Application No: LY/6/21/HH
Site Address: 1 The Paddock Lyminster BN17 7QH
Description of works: Erection of single storey front and rear extensions and internal alterations. This application affects the character and appearance of the Lyminster Conservation Area.

OWPC36920

CLIENT	Mr & Mrs Kelly		
SITE ADDRESS	1 The Paddocks Lyminster BN17 7QH		
PROJECT TITLE	Proposed single storey front and rear extensions and internal alterations		
STATUS	PRELIMINARY		
DATE	29th Mar 2021	DRAWN BY	EL
DRAWING TITLE	PROPOSED ELEVATIONS		
SCALE	1 : 50 @A1	DRAWING NO.	A104

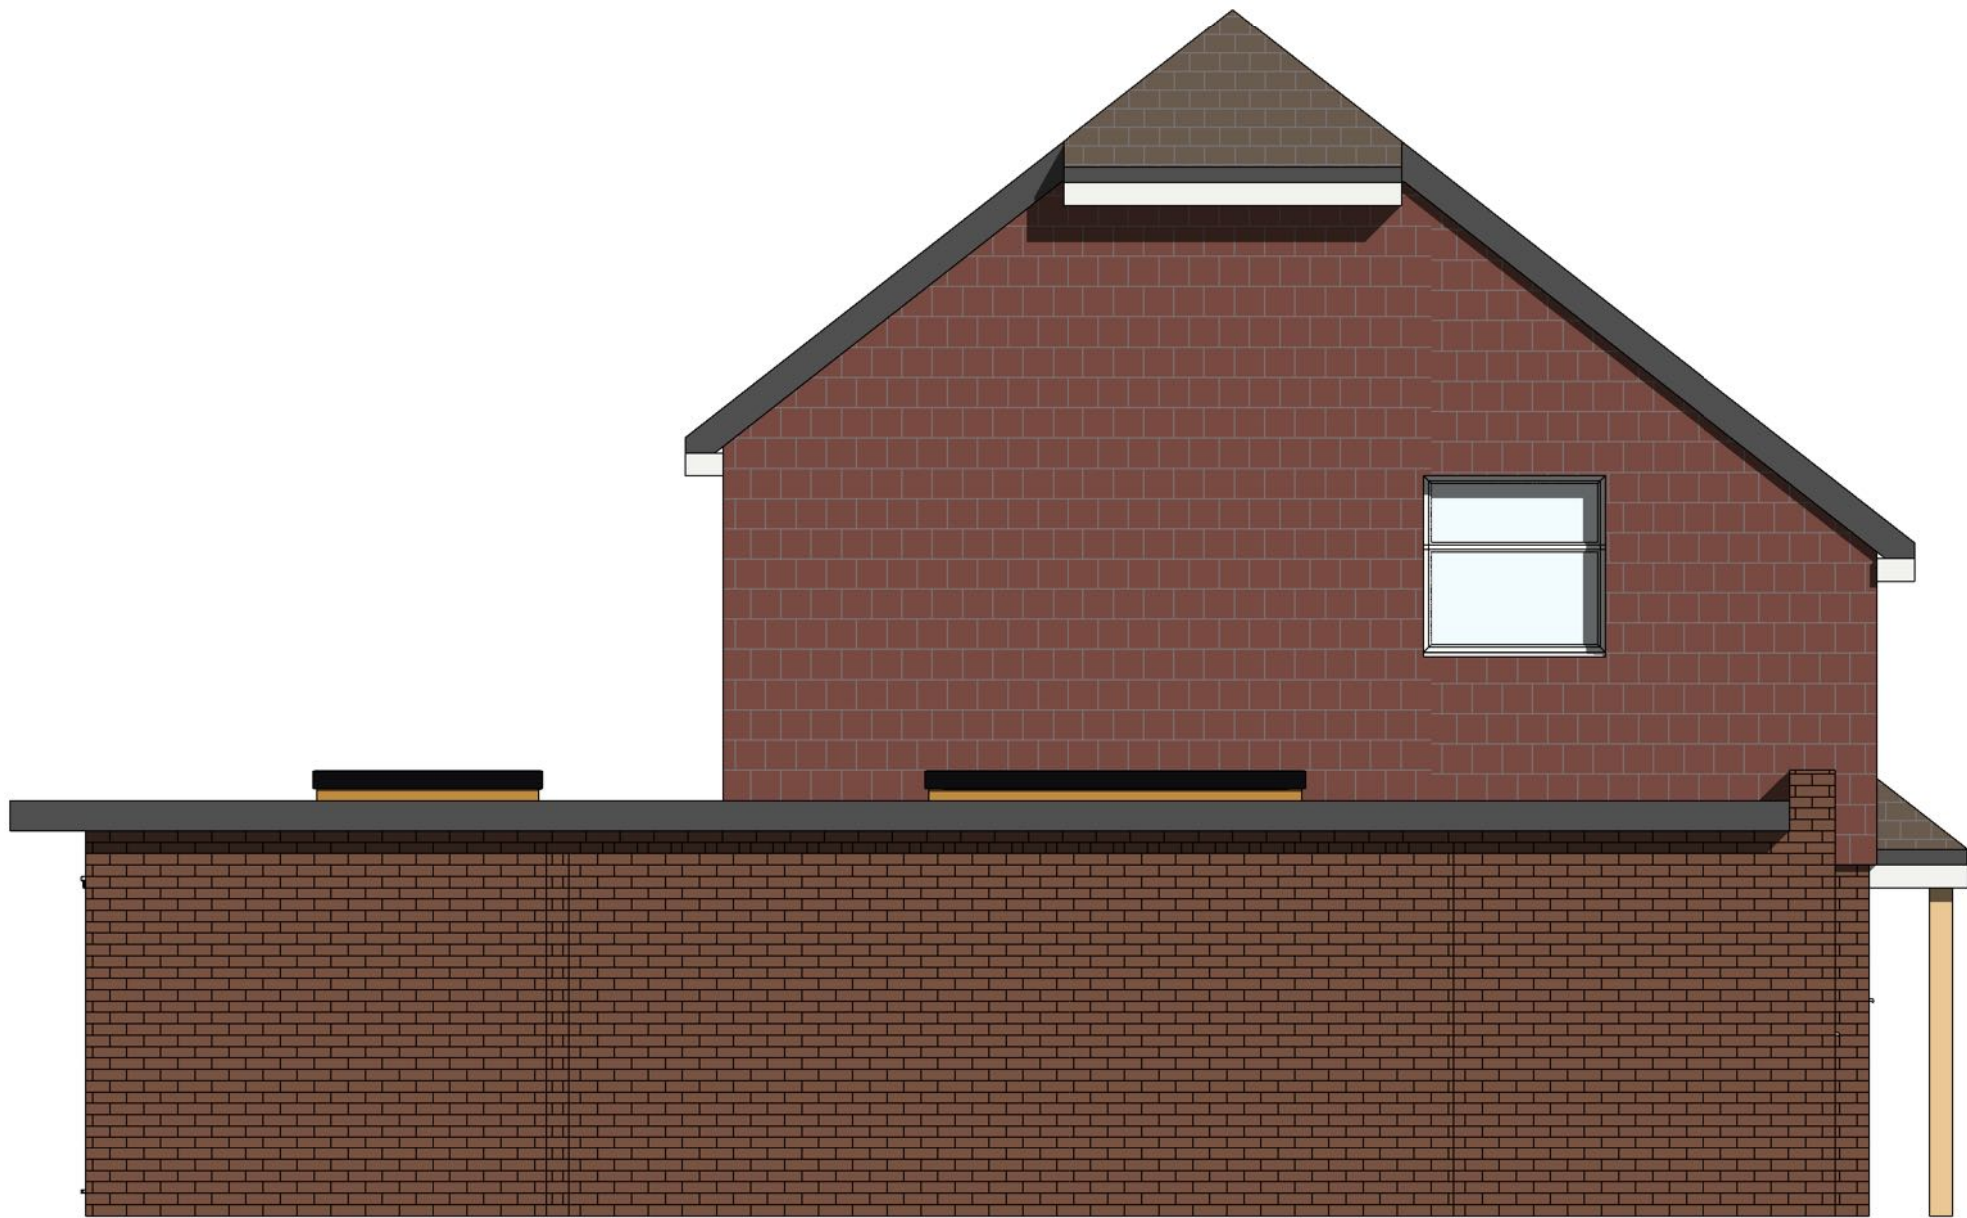
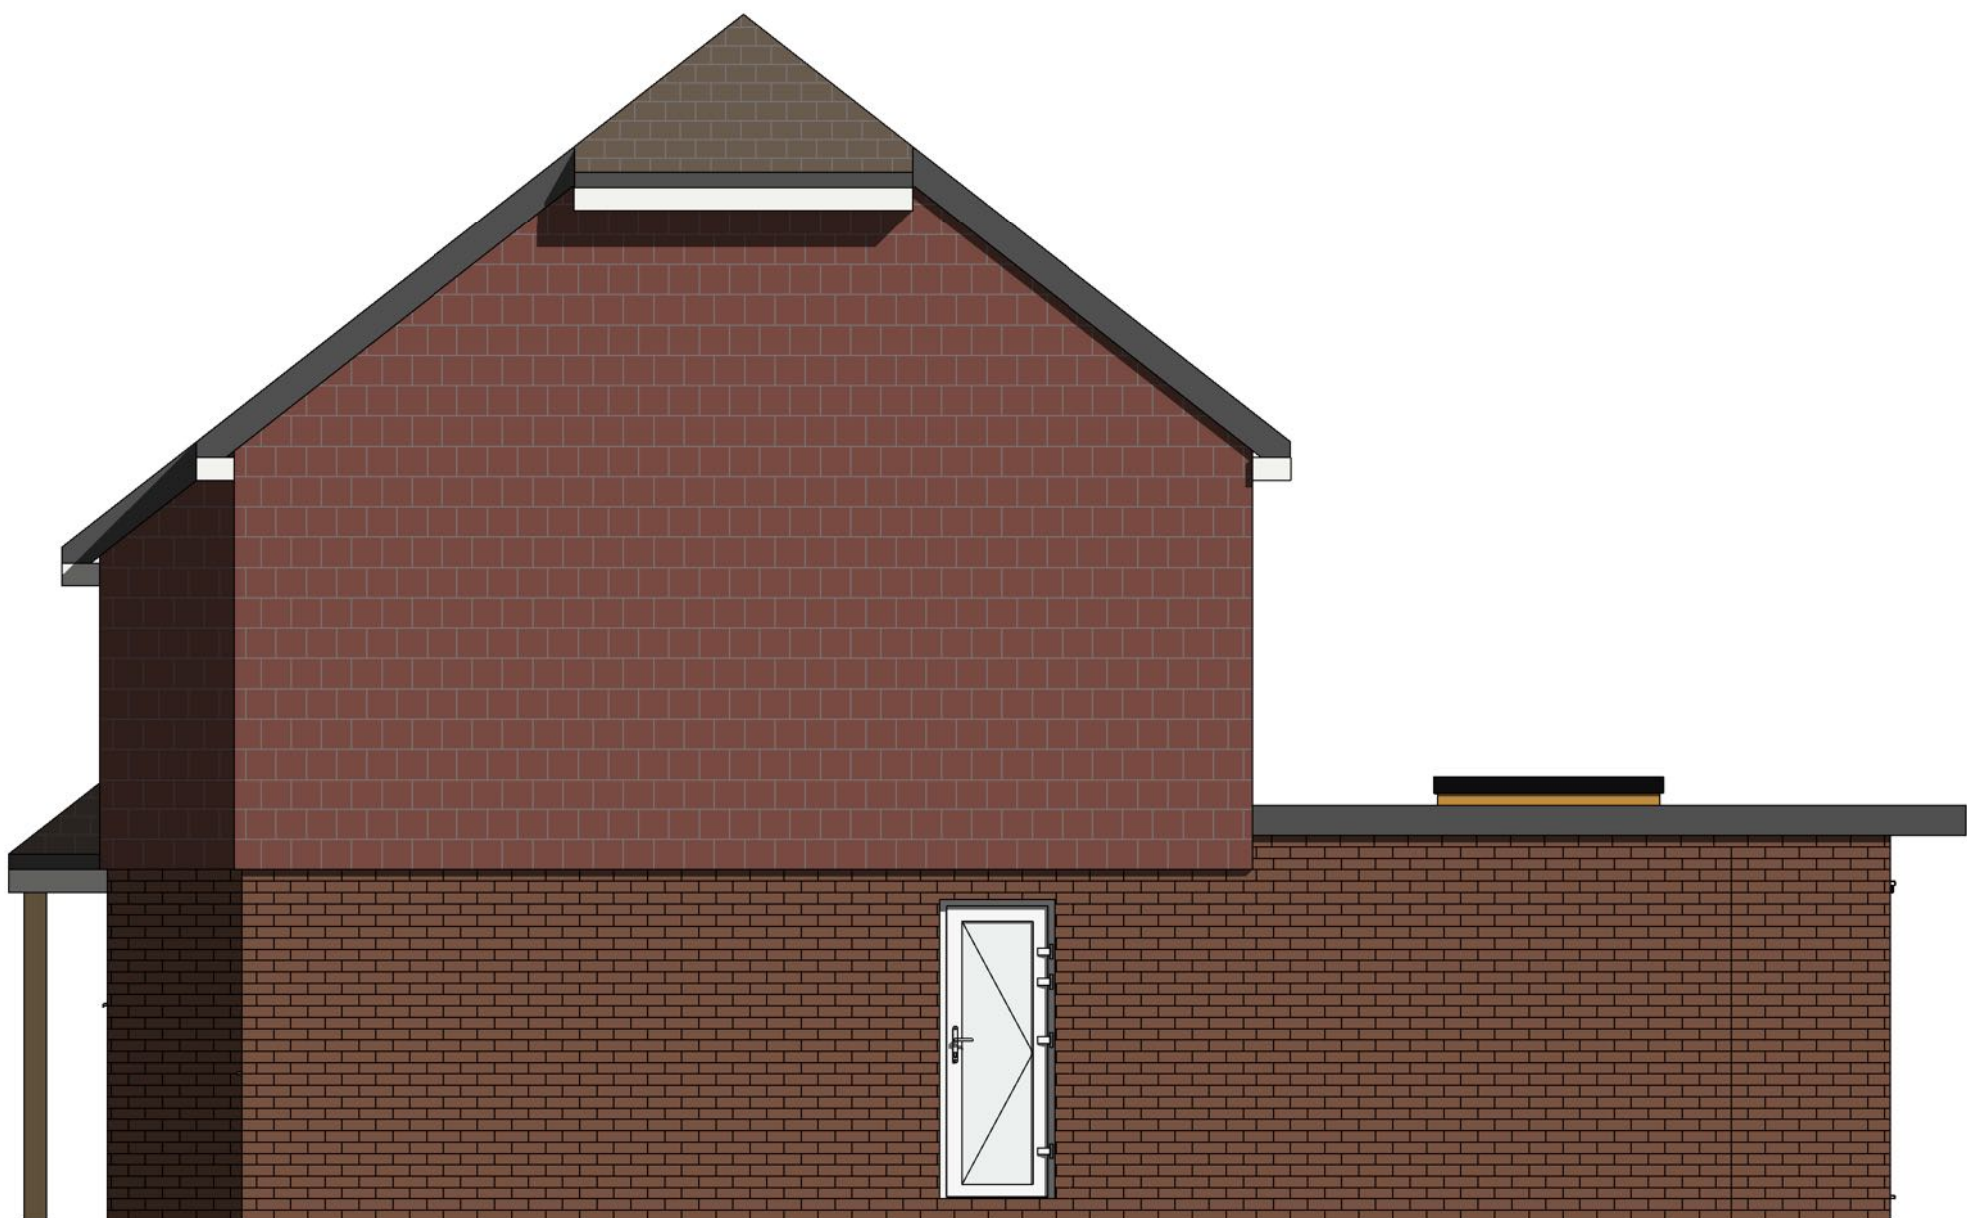
The appearance of the top of the front extension could be improved with say the use of a brick soldier course or brick corbelling rather than the stretcher bond shown on the drawings.
